**TOGA Central (SSD-33258337) - Notice of Exhibition**

Thank you for your correspondence via the Major Projects Portal on 25 August 2022, requesting Transport for NSW (TfNSW) to review and comment on the above.

## **Attachment A: Items to be addressed as part of the Response to Submissions (RtS)**

**VEHICLE SWEEP PATH ASSESSMENT**

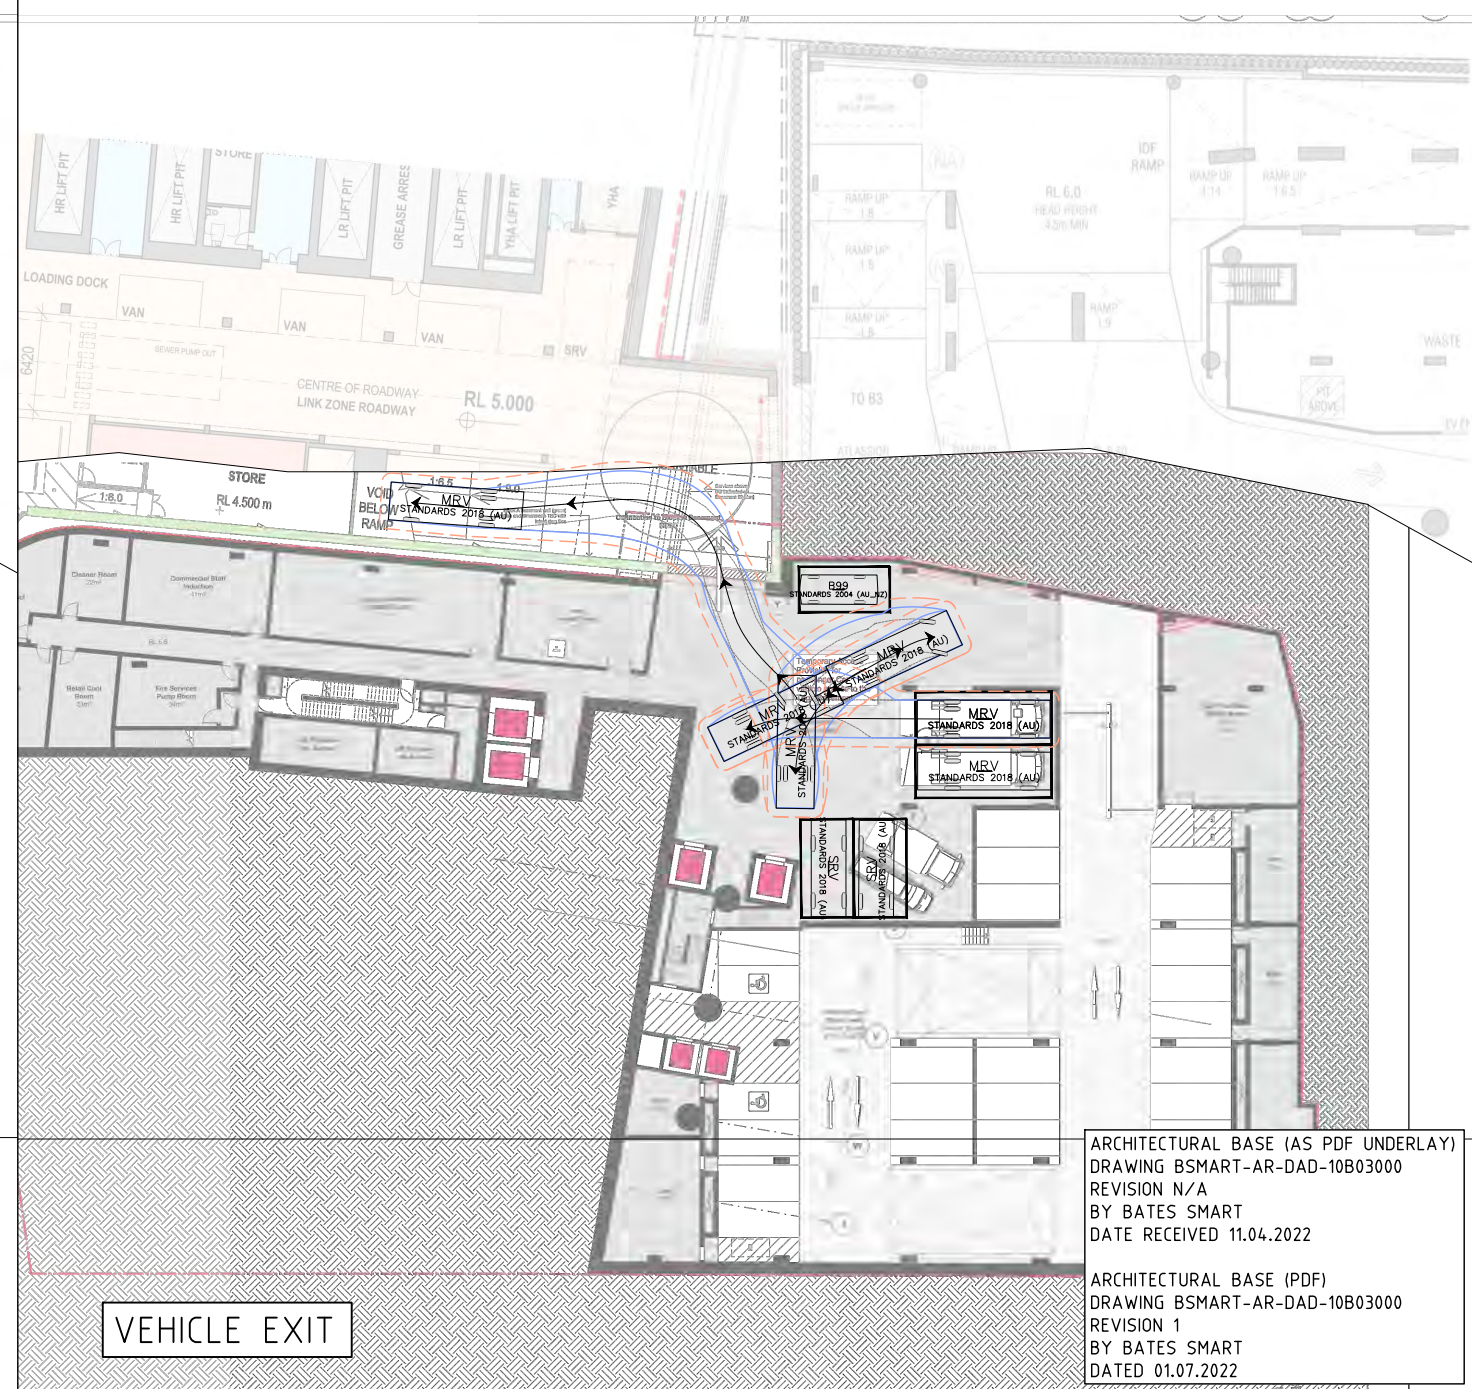
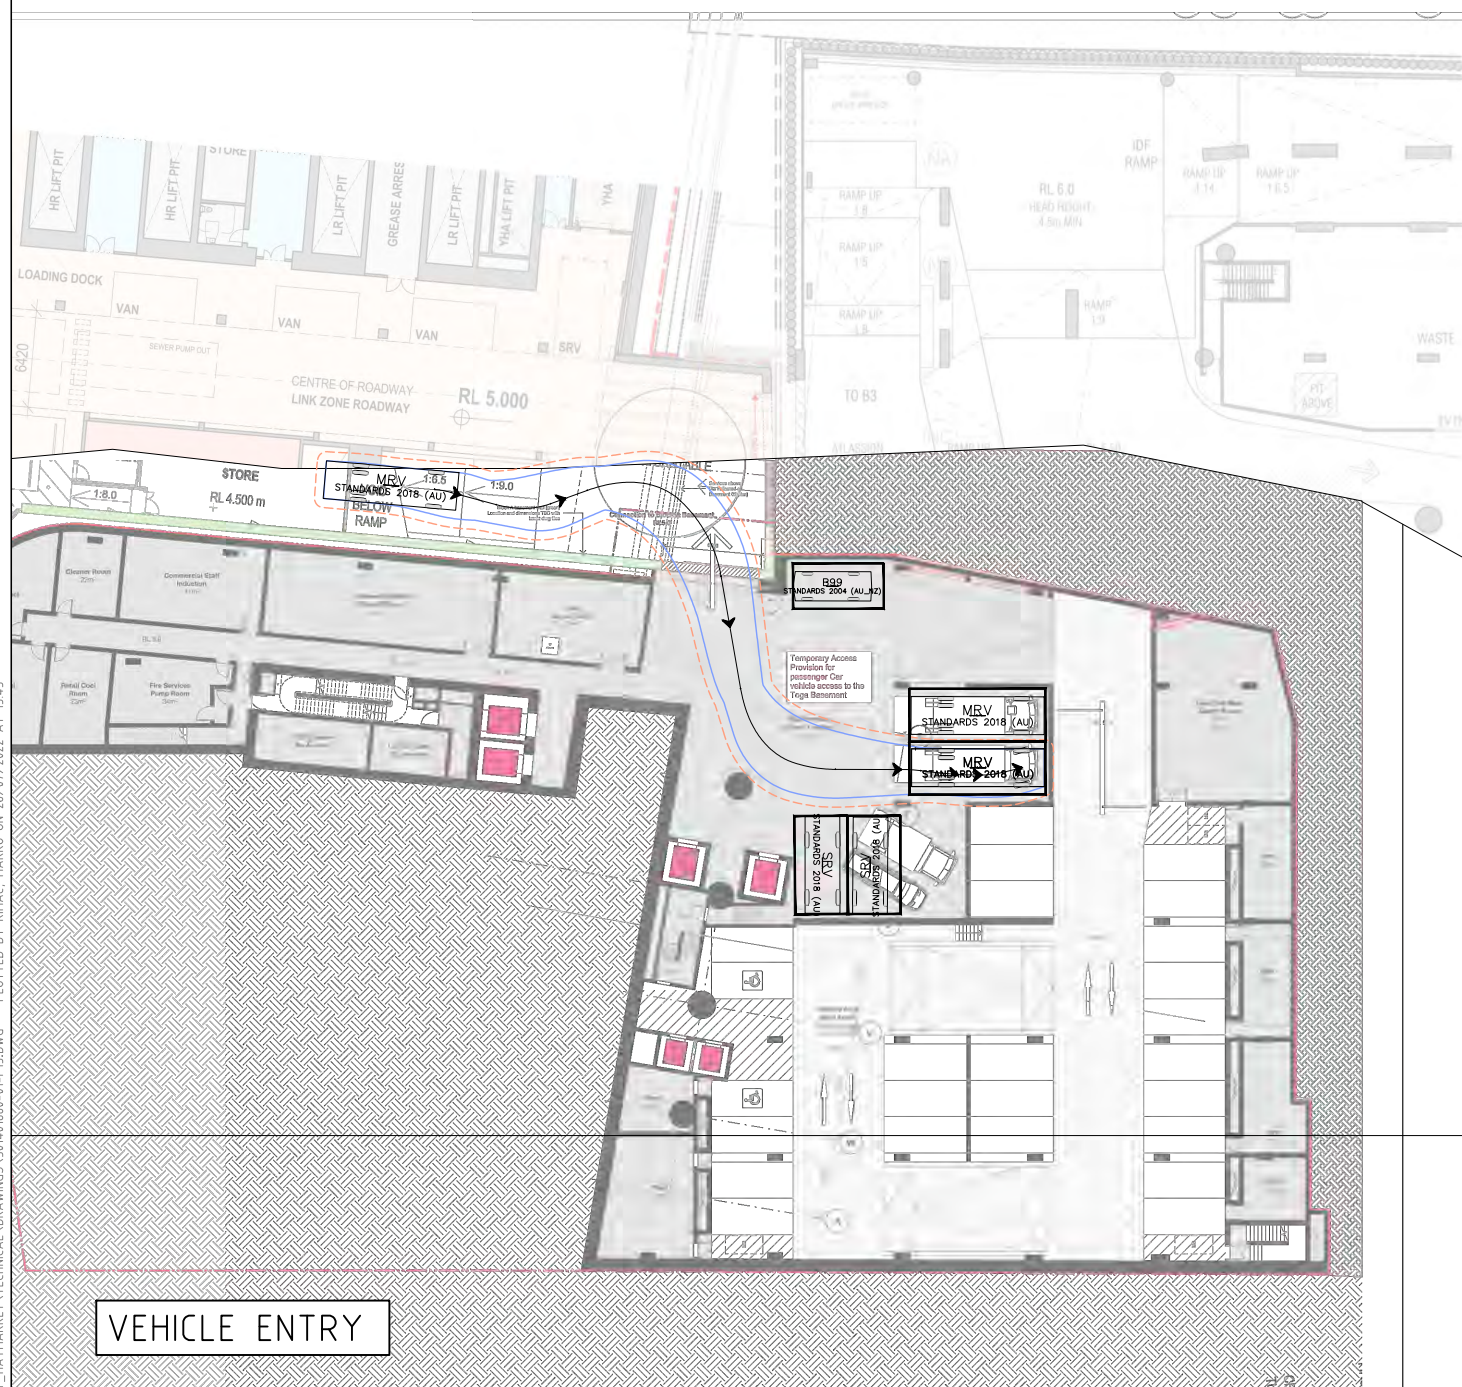
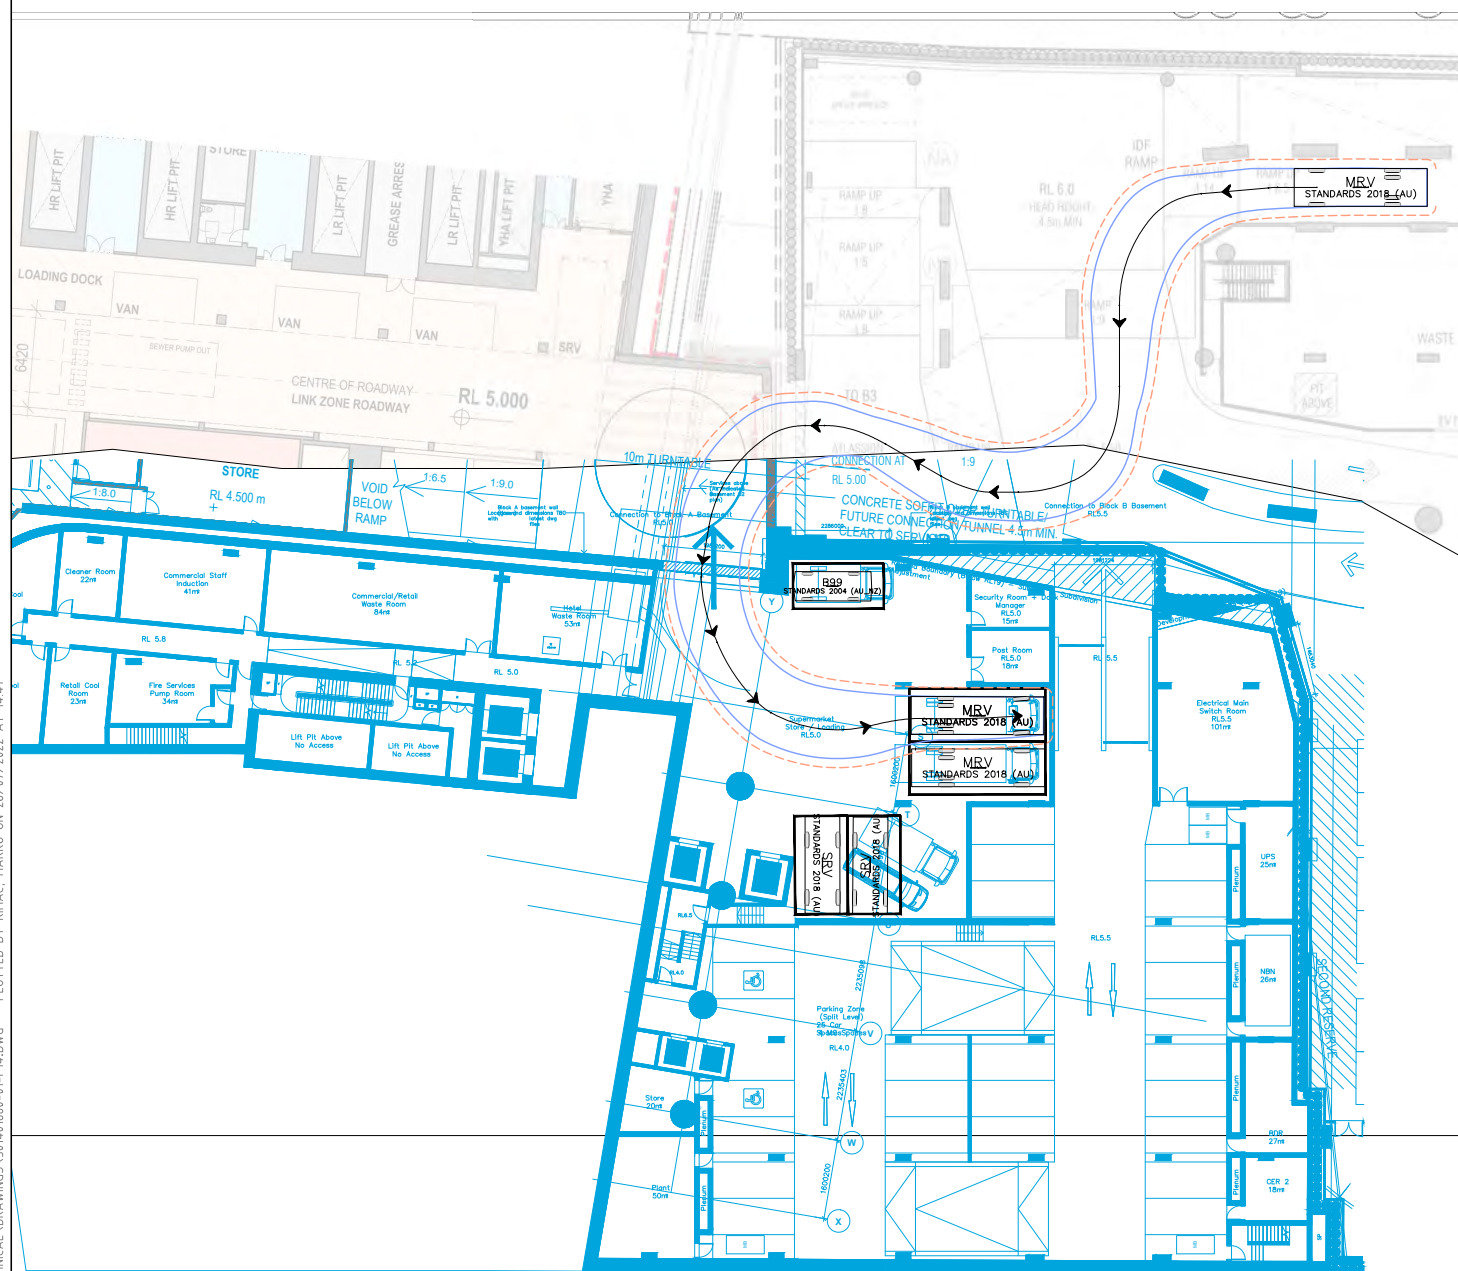
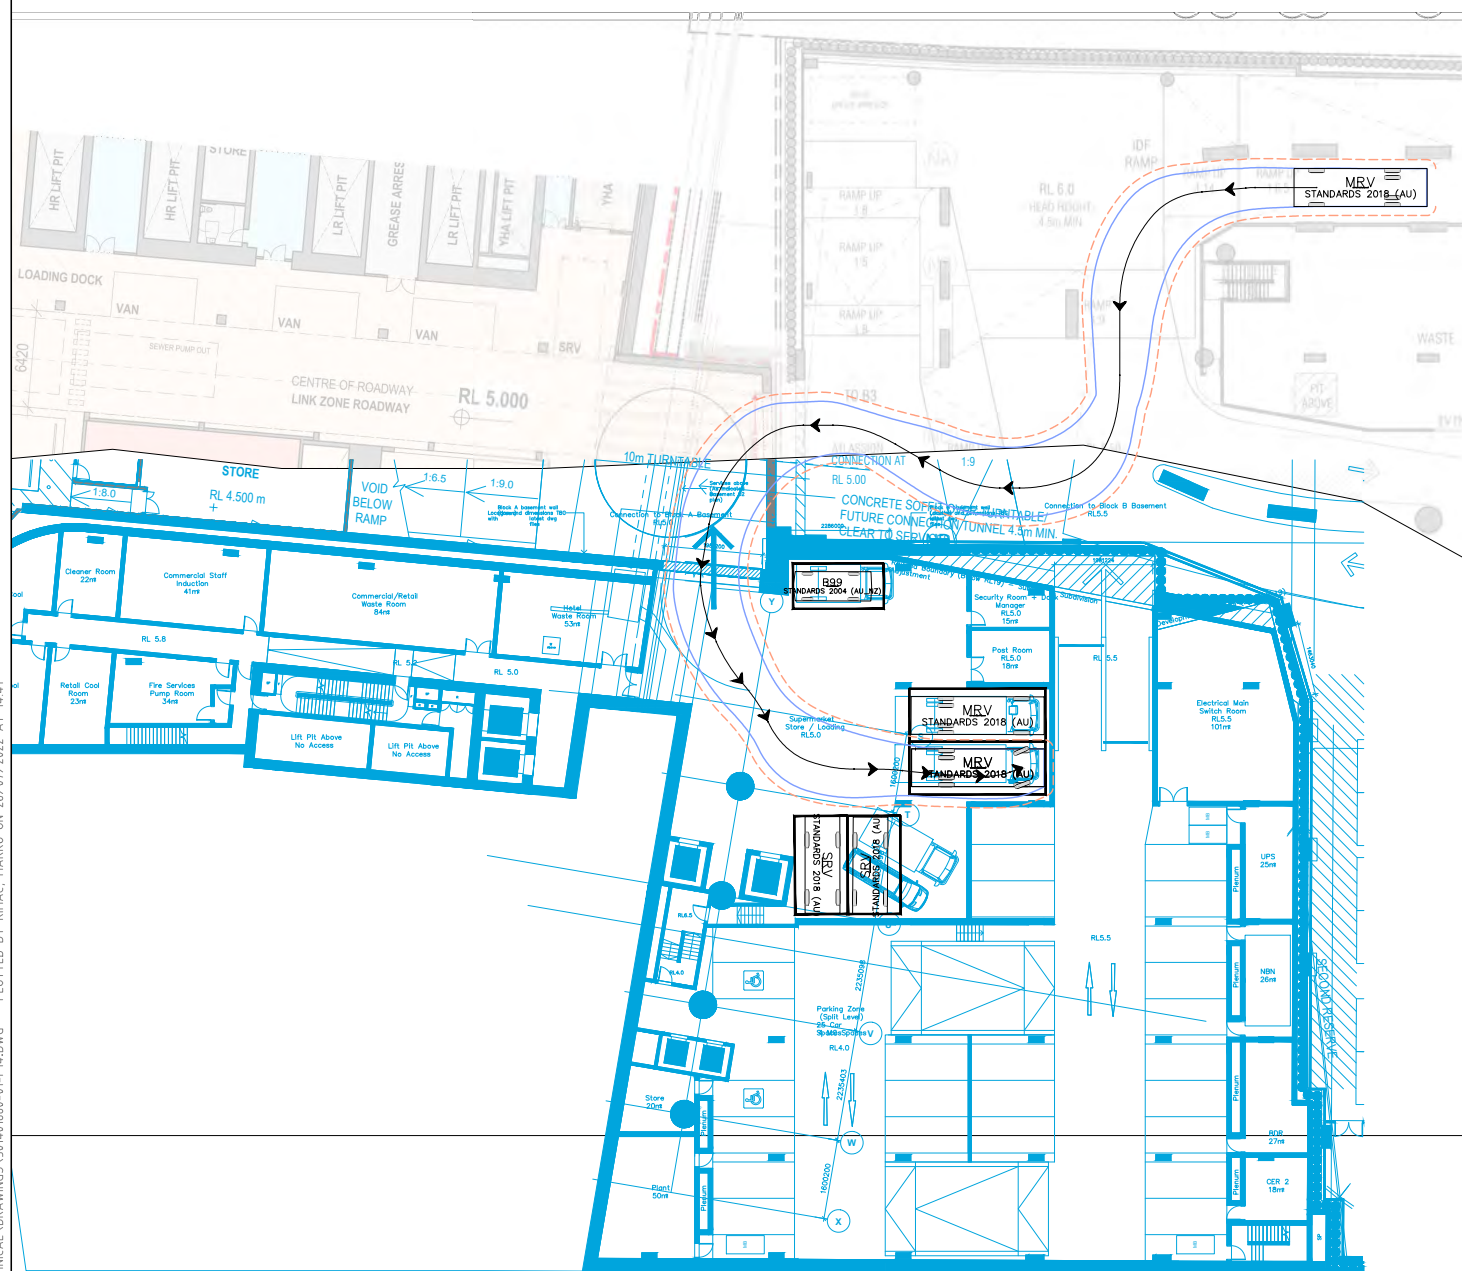
- The proposed development would be provided with a total of 5 loading bays (3xB99 spaces and 2xMRV spaces). However, the Traffic Report states that the proposed development is required to provide up to 22 loading spaces based on the Council's DCP 2012; and
- A total of 106 car parking spaces would be provided for the proposed development at a location where high level of public transport services are available.

- The number of loading bays proposed on site is substantially lower than the required number of loading bays as per Sydney DCP 2012; and
- Site loading and servicing demands generated by the site should occur on-site as outlined in Sydney DCP 2012 Section 3.11.13 and rates specified Schedule 7.8,

It is requested that the applicant provides additional loading bays in accordance with council standards. This could be achieved by converting some of the car parking spaces to loading bays for the same reasons outlined above regarding the bicycle parking requirements.
